Development Facilitation Team (DFT) – Review Comments

Project No: PR-2024-010074 Date: 11/6/2024 Agenda Item: #3 & 4 Zone Atlas Page: B-14

Request: 1. EPC Site Plan Sign-Off for EPC Majoy Amendment. Amended The Controlling Site Development Plan for Subdivision to Remove Tract A & Abandon the Controlling Design Standards to Follow the integrated Development Ordinance (IDO) 2. Proposed 3-Story Self-Storage Center. Each Floor is Approximately 32,678 Sq Ft Totaling 98,034 Sq Ft

Application For: SI-2024-01533 – EPA SITE PLAN DFT

Drawing file: PR-2024-010074_SI-2024-01533_November_6_2024 (EPC SPSO) / Utility Plan.pdf

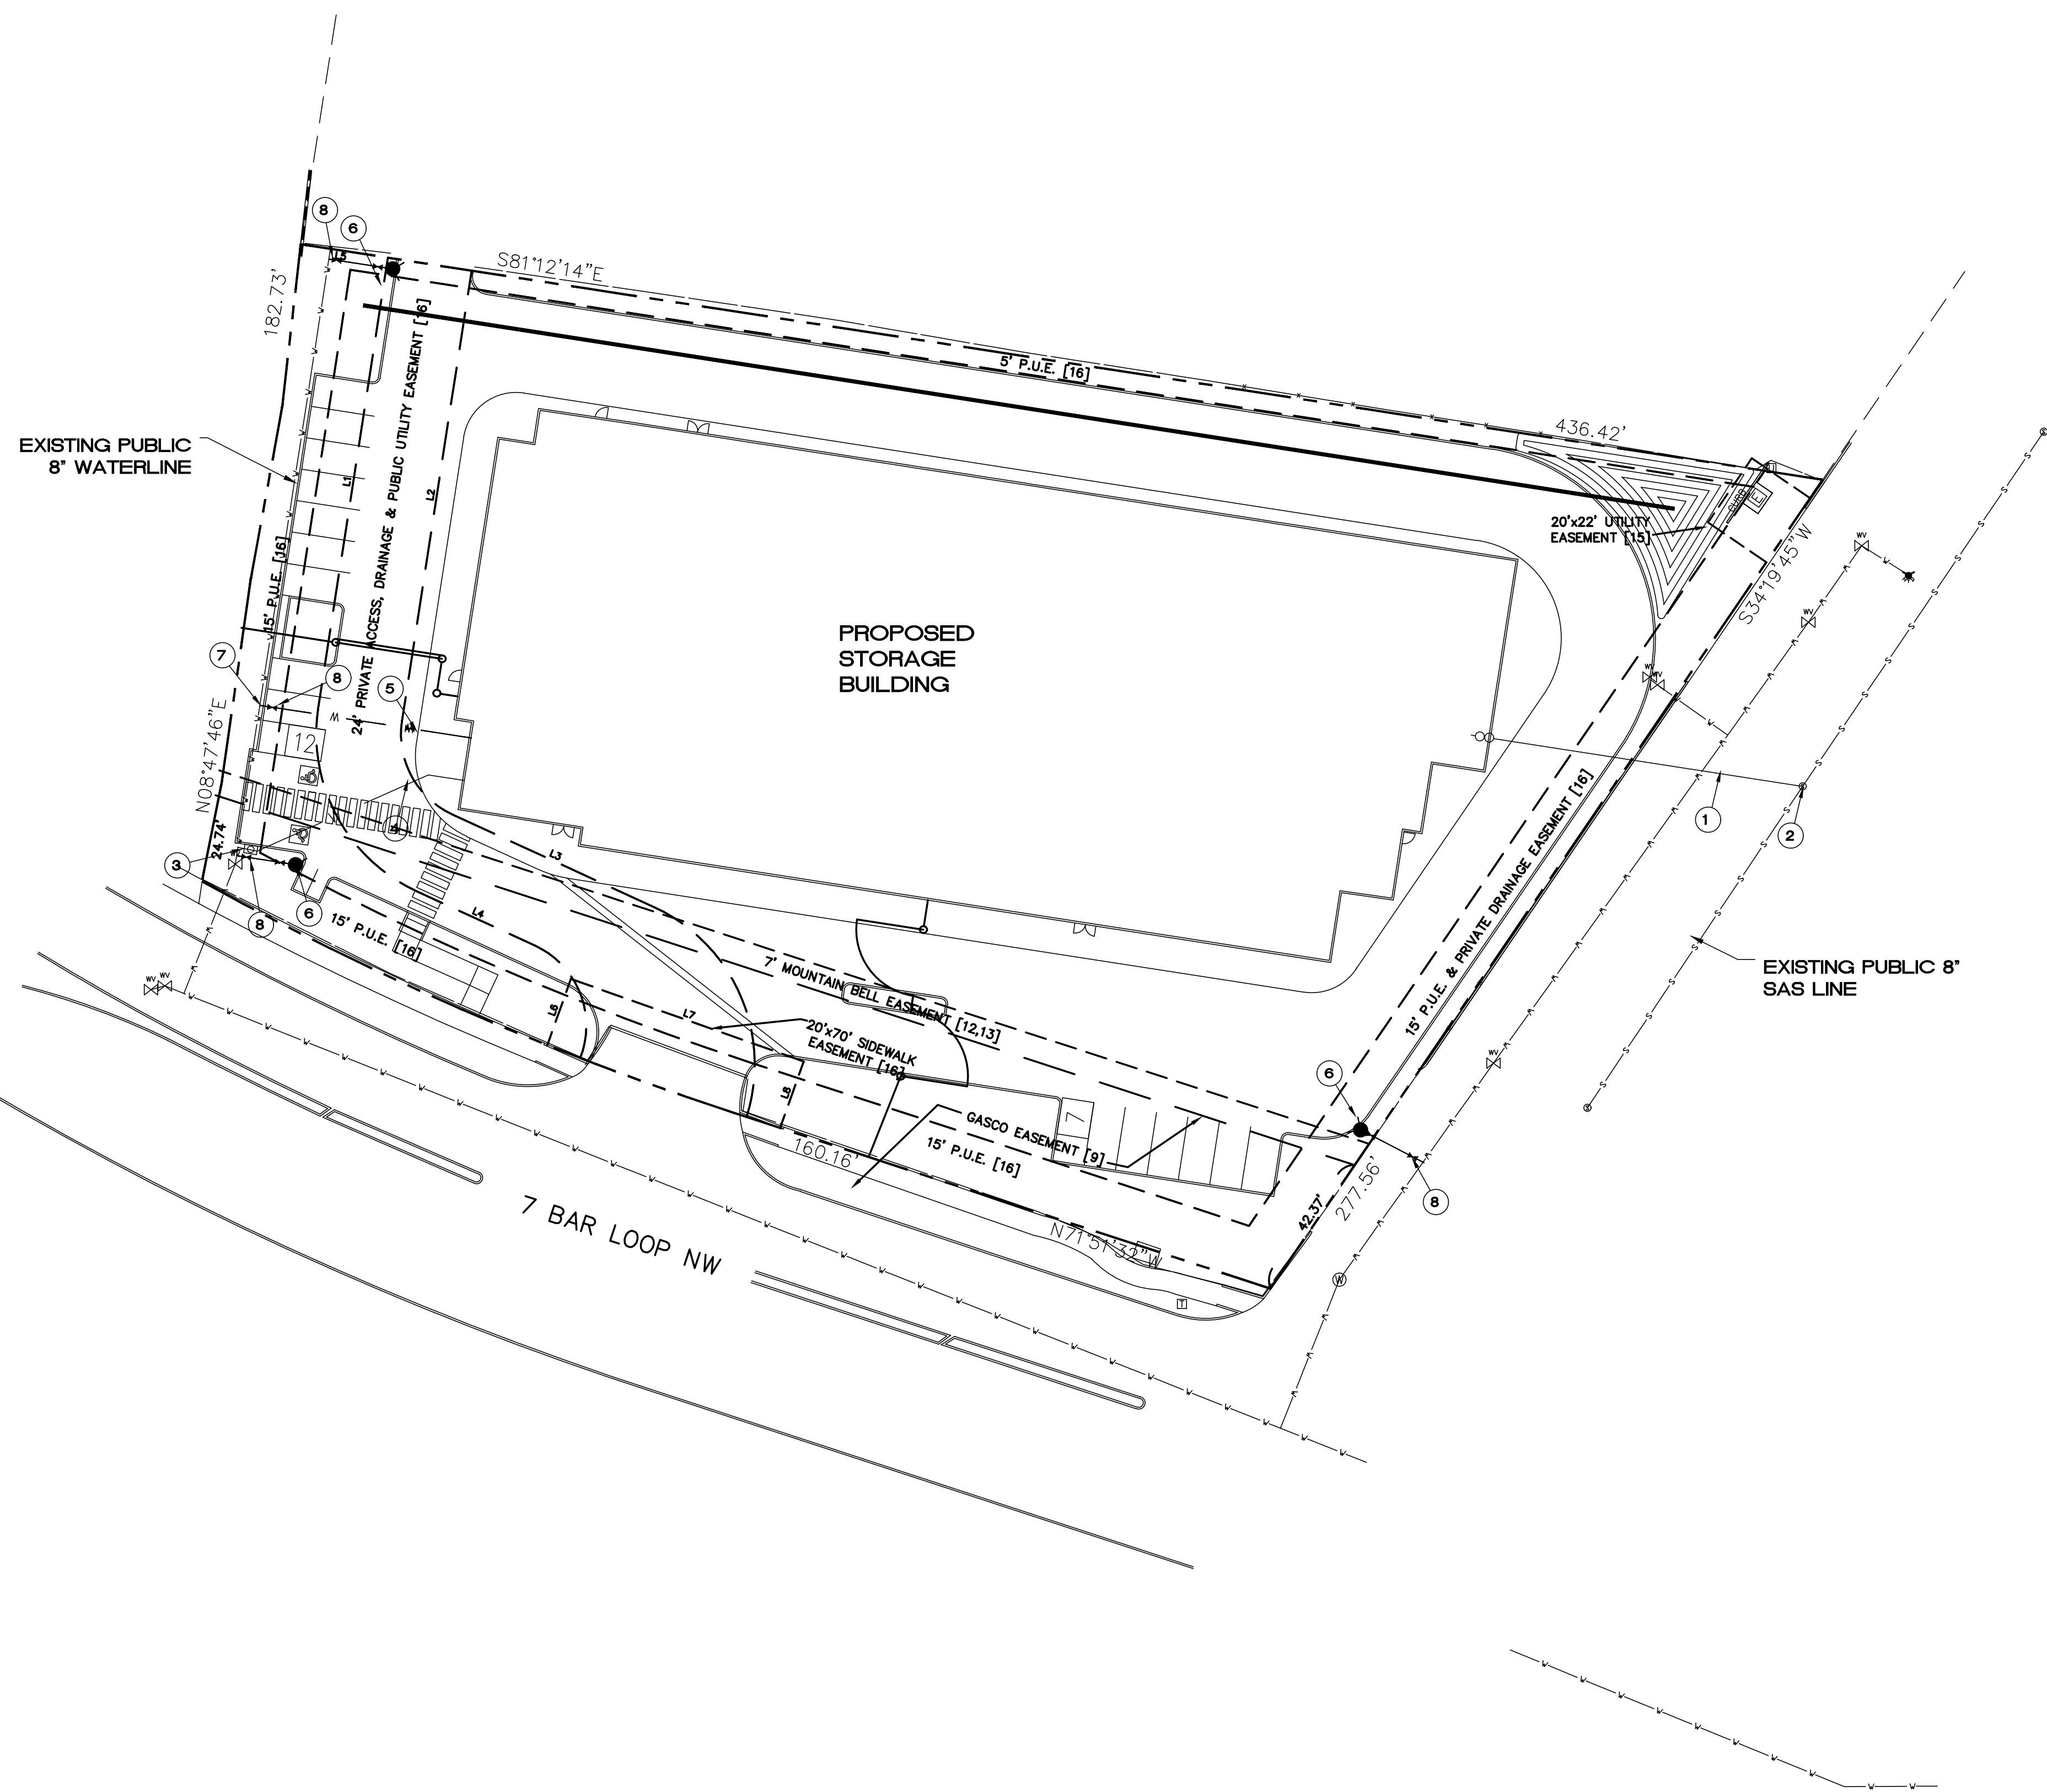
1. Availability Statement 240605 has been completed and provides conditions for service.
2. For the proposed surface above the waterline, please verify that there is no curb and gutter placed within the existing waterline easement.
3. Previous comments:
 - a. Please update the standards on the Utility Plan to reference Water Authority standards to be followed.
 - b. Please show a public valve and private valve for each proposed fire line (this includes the private fire hydrants).
 - c. Reference the public waterline easements. (Document number and filing date)
 - d. Please add a note stating that all public infrastructure shall be constructed with a connection permit through the Water Authority.
